Subject: SP-26-00004 Moulton
US 97 milepost 140.76 Left

We have reviewed the proposed preliminary plat and have the following comment:

MOULTON SHORT PLAT

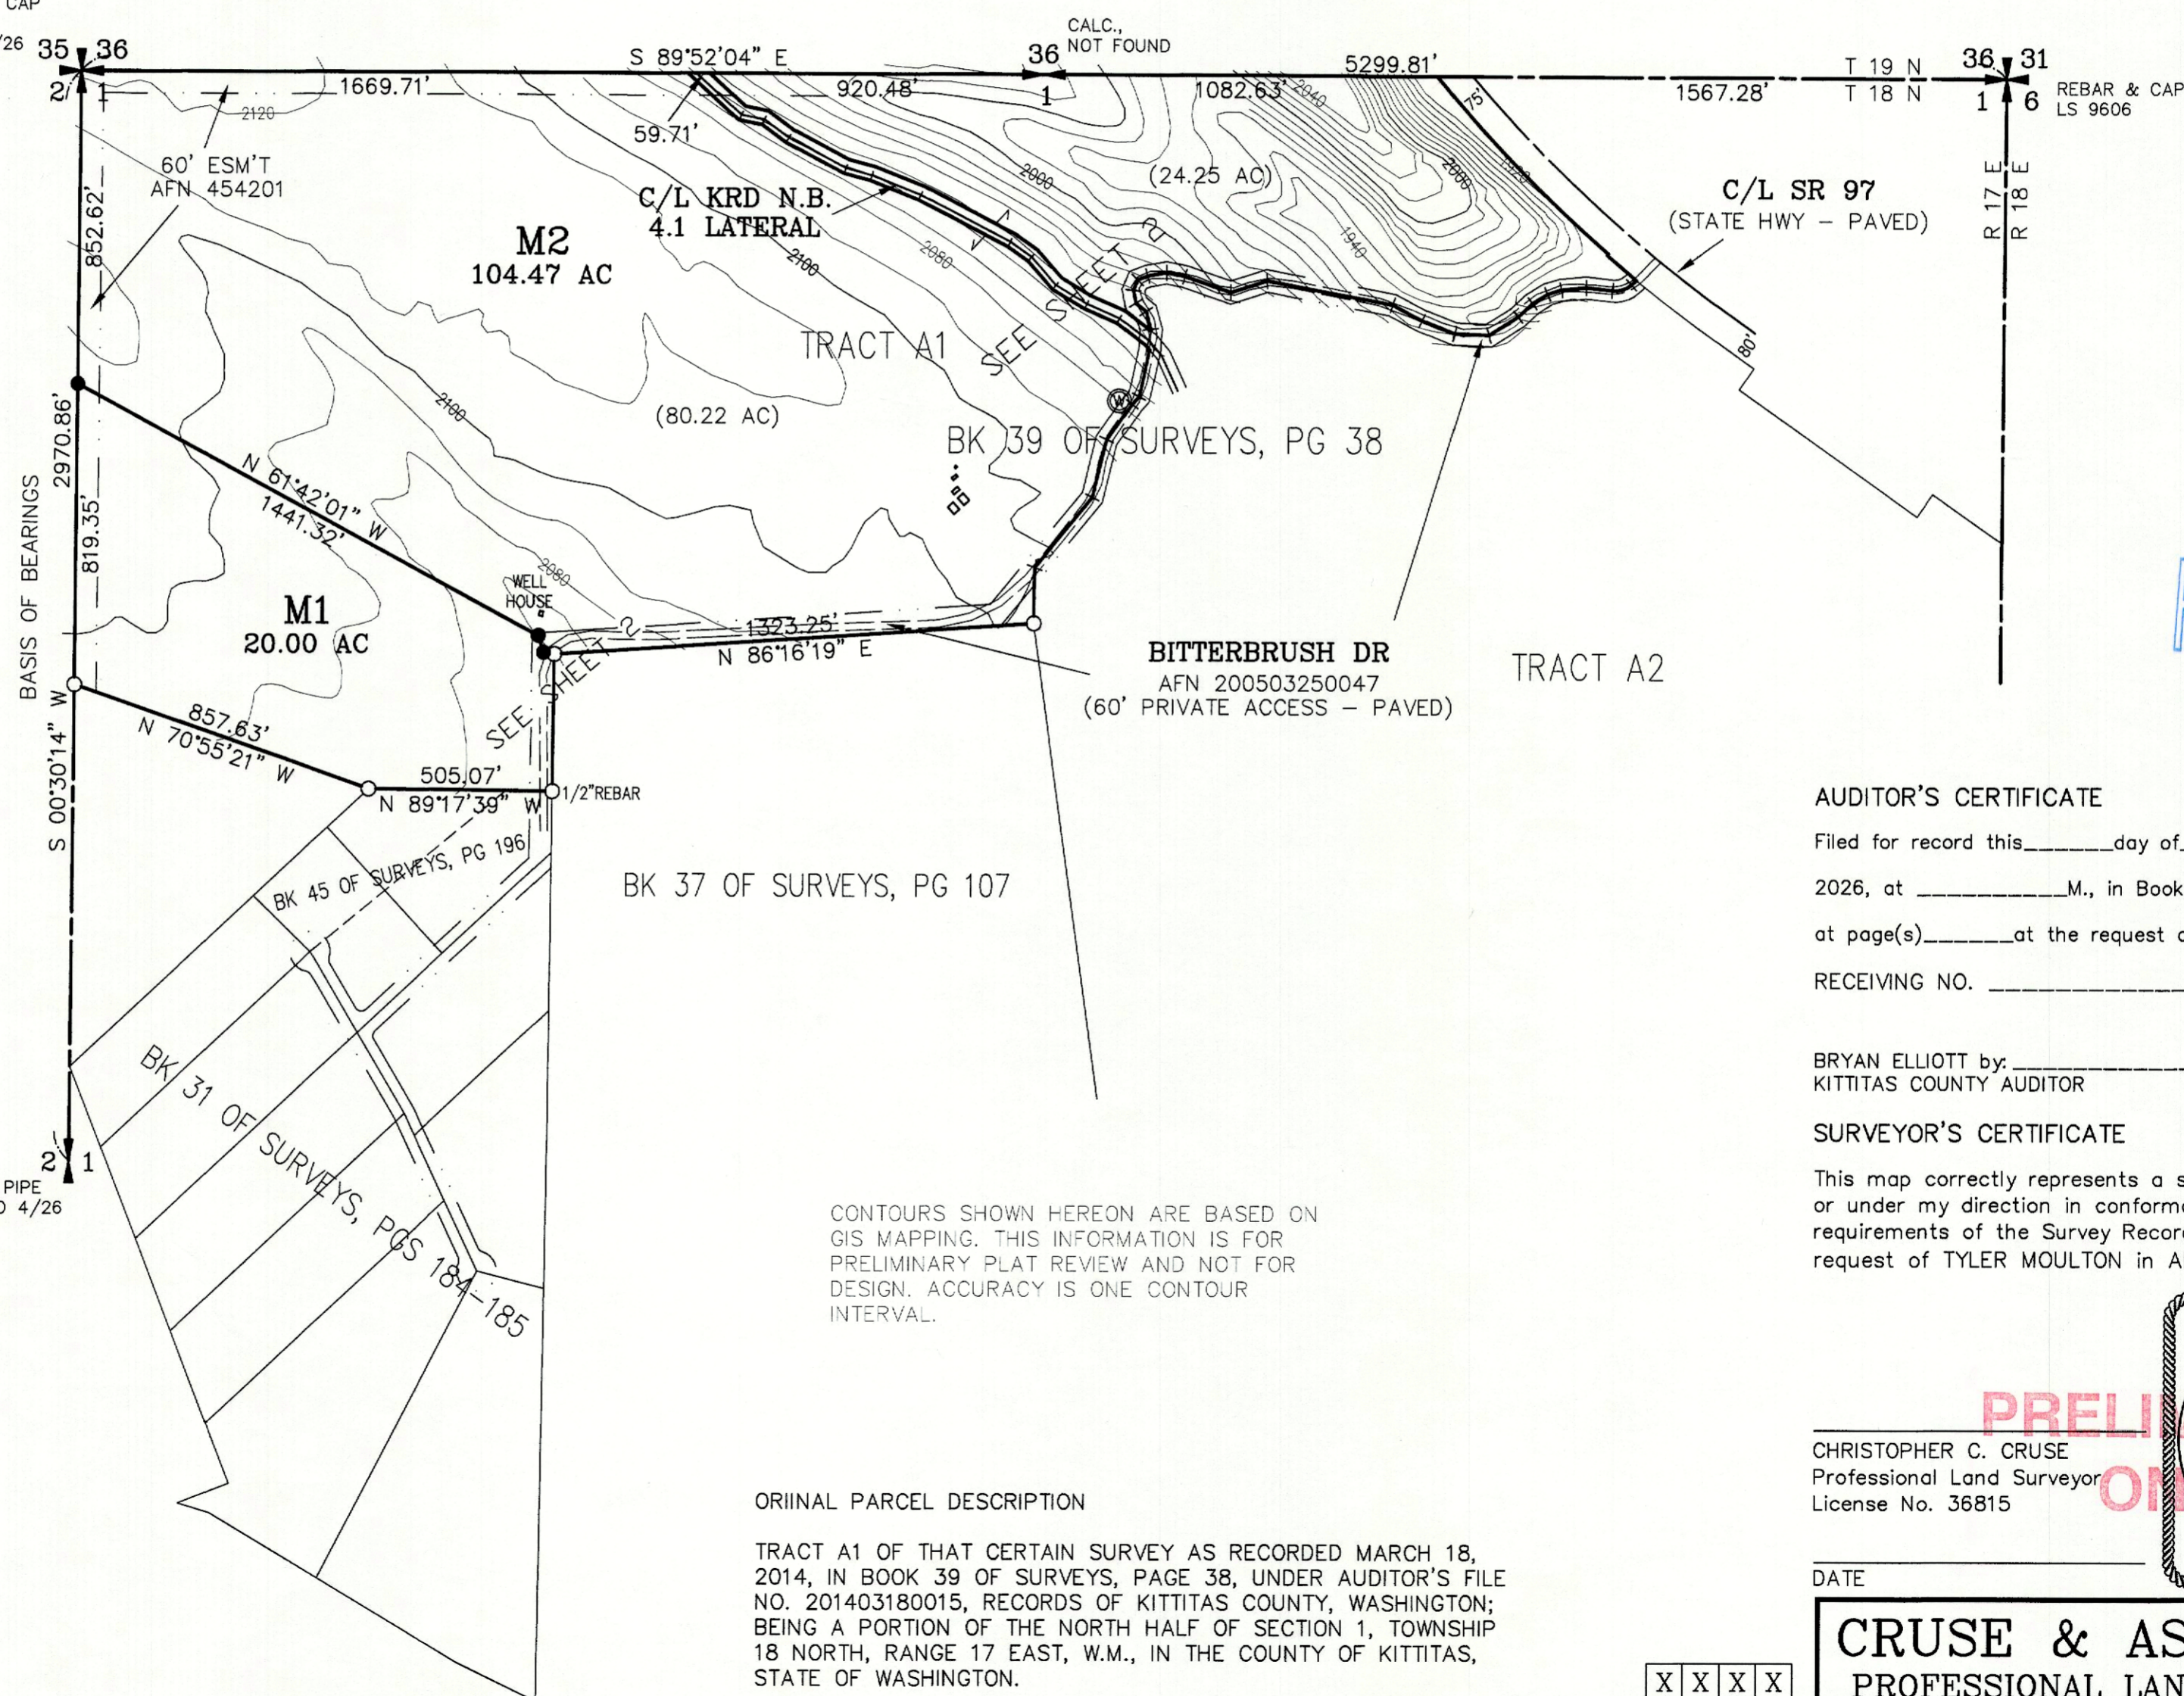
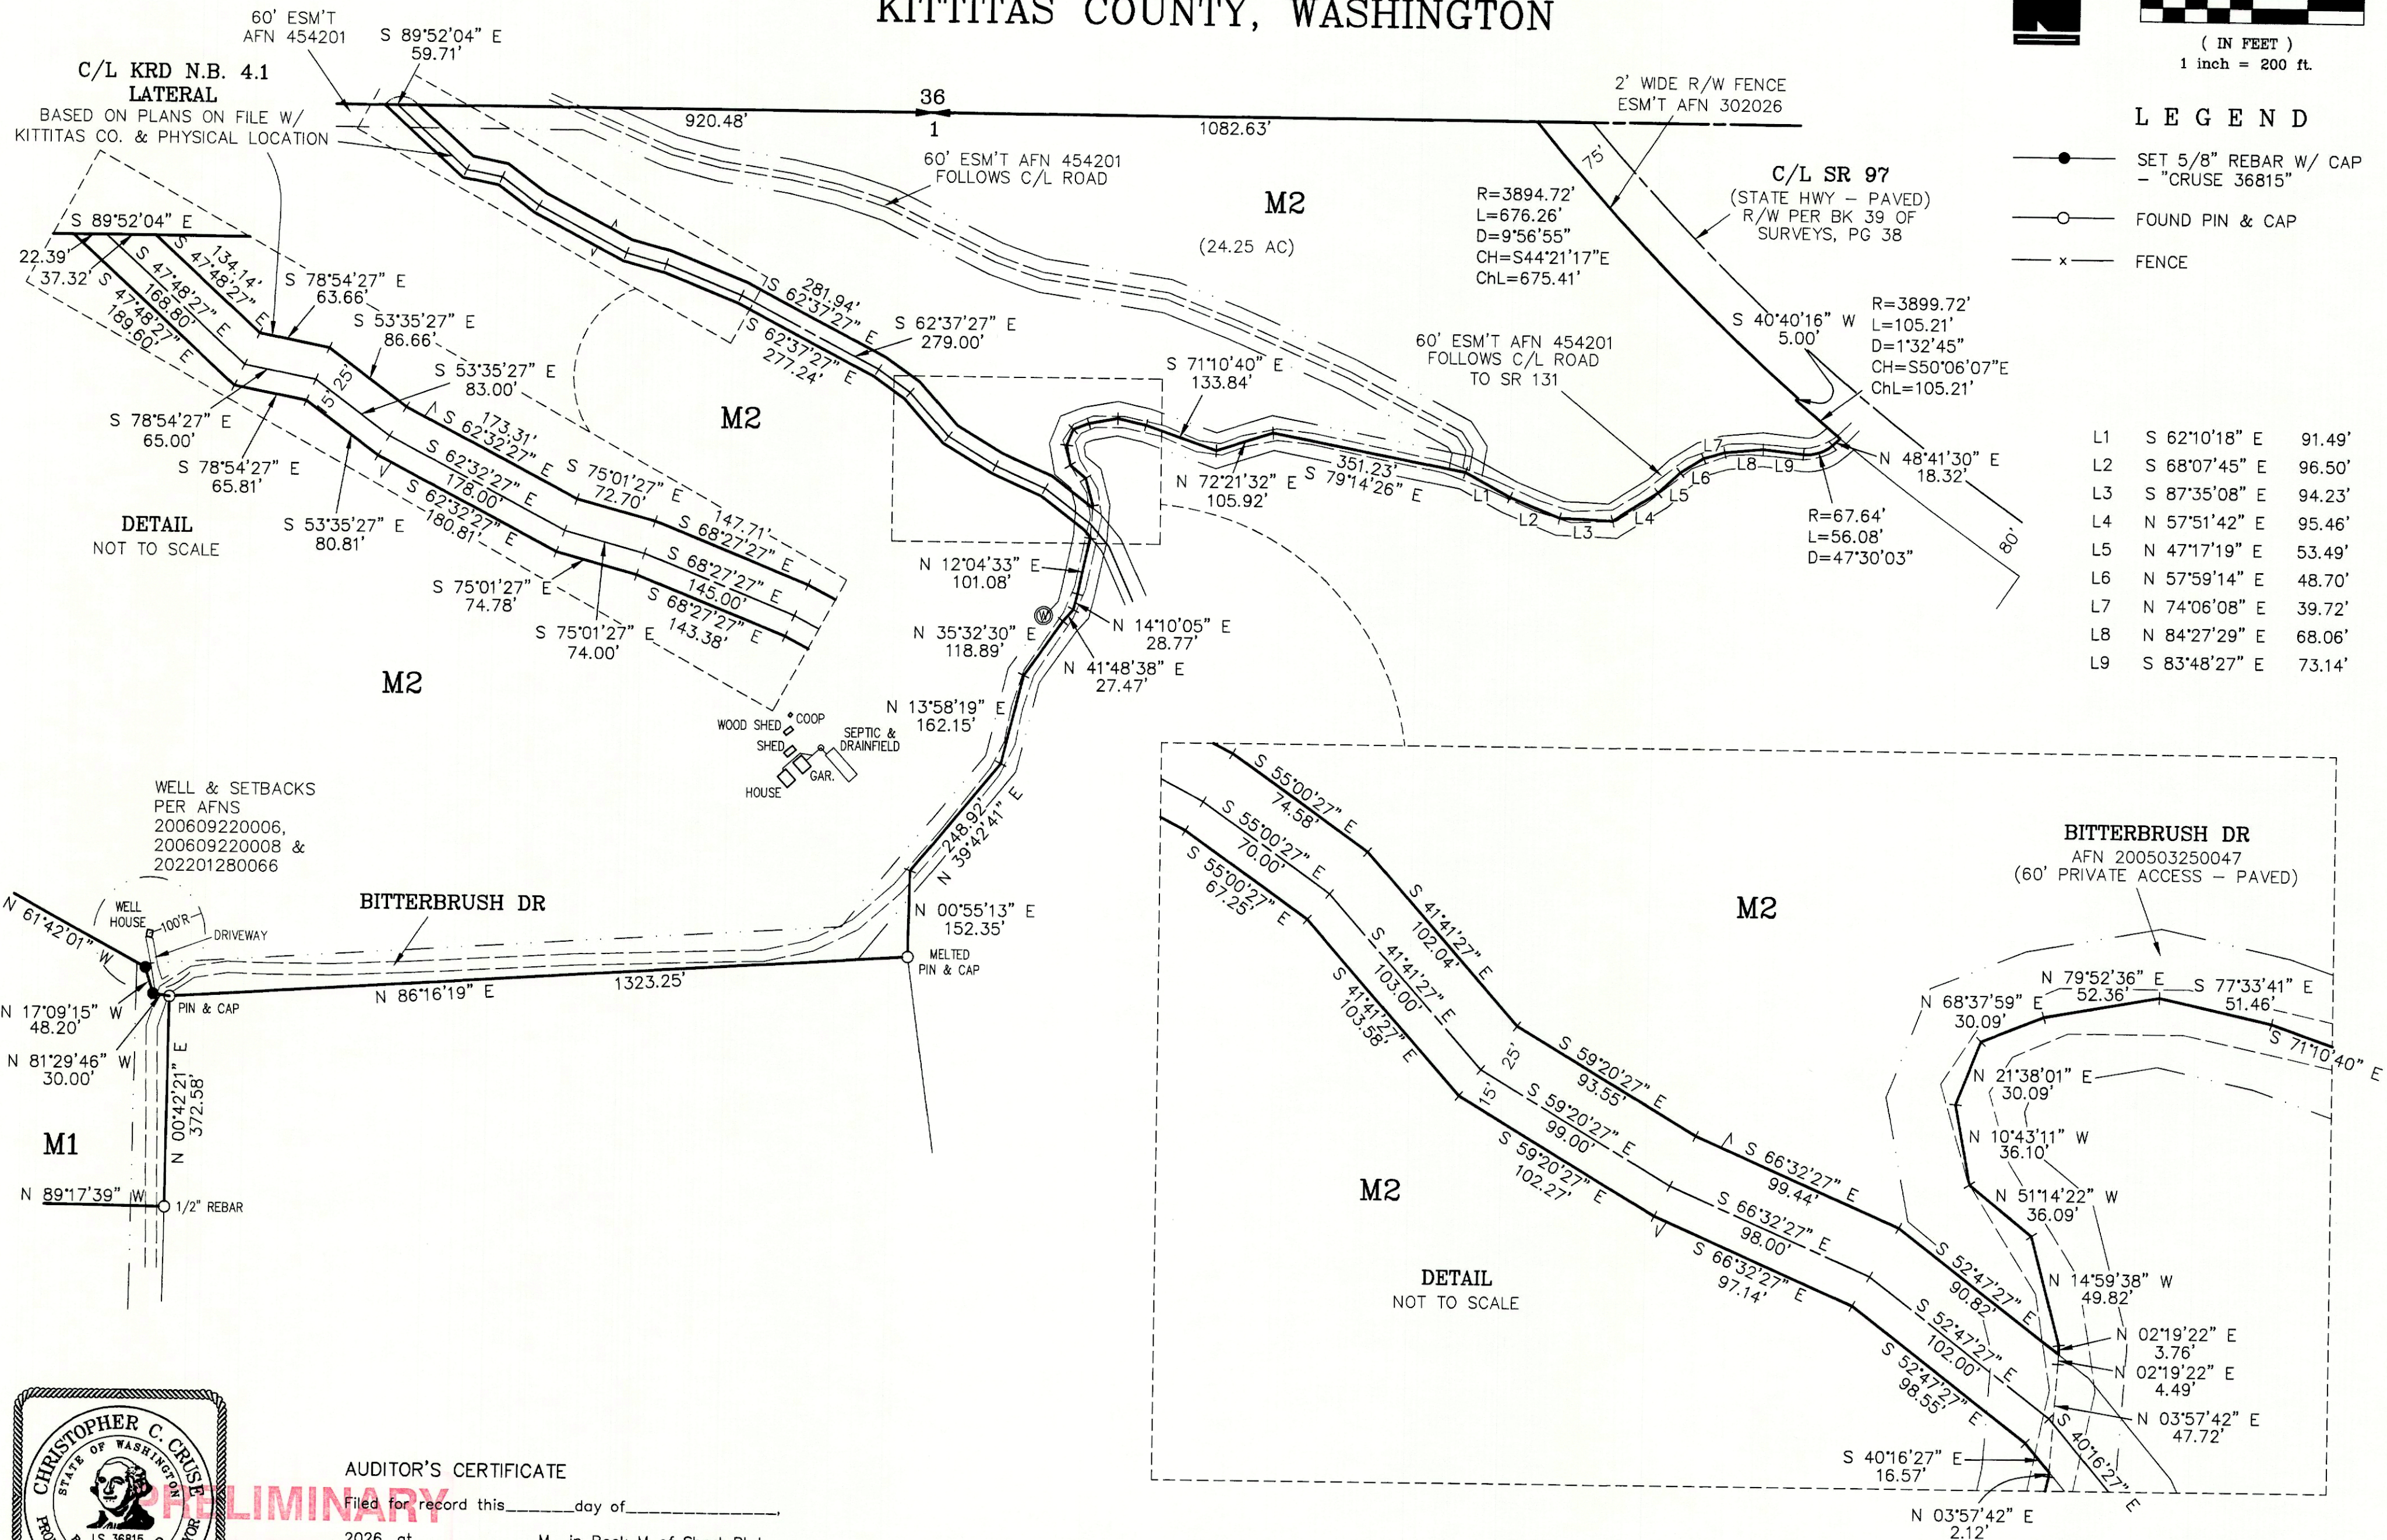
The subject property is adjacent to U.S. Highway 97 (US 97), a Class 1 managed access highway with a posted speed limit of 65 miles per hour. Currently, access to the property is via Bitterbrush Drive, a permitted joint use approach at milepost 140.76 left. This approach was permitted to serve as a residential/farm access not to exceed 25-feet in width and may continue to be used; however, the permit must be updated. No additional approaches to US 97 will be allowed. The property owner is required to contact Mark Kaiser of the WSDOT - South Central Region Office at (509) 577-1668 to update the permit.
